Project: SSD 5175 Mod 2 Eastern Creek Business Hub s96(2) modification request to amend the indicative concept plan, urban design guidelines and permitted uses

Re: Council comments for the further Response to Submissions

Figure 11: Vehicle access

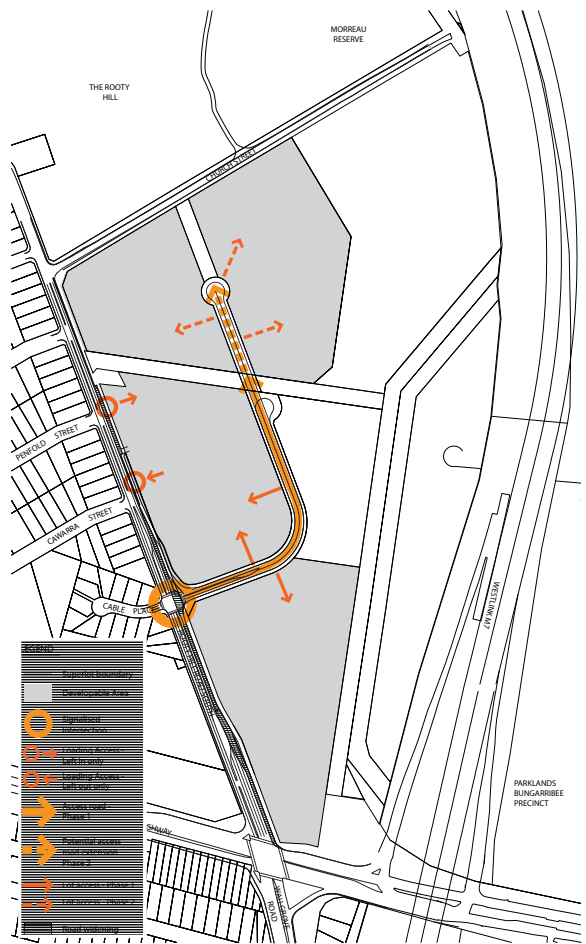
Traffic Management
The following comments are provided by Council's Access and Transport Management section: 1. Council's local industrial road is 20.5 m wide which includes a 13.5 m wide carriageway and footway 3.5 m wide on each side. The proposed 12 m wide carriageway does not comply with the Blacktown Development Control Plan (DCP) requirement and is not supported. 2. A turning head in the form of a cul-de-sac with a carriageway radius of 13.5 m is required at the end of the Beggs Road. A three point turn by a truck on a public road is not supported. 3. Our preference is that the Beggs Road be realigned at right angle (90 degrees) where it meets with Rooty Hill Road South. 4. We note that RMS require a median strip to restrict access to Beggs Road as left-in and left-out. We support this initiative. 5. We would only accept RMS parking rates where no parking rates are available for a proposed development in Council's DCP. As Council has parking rates in its
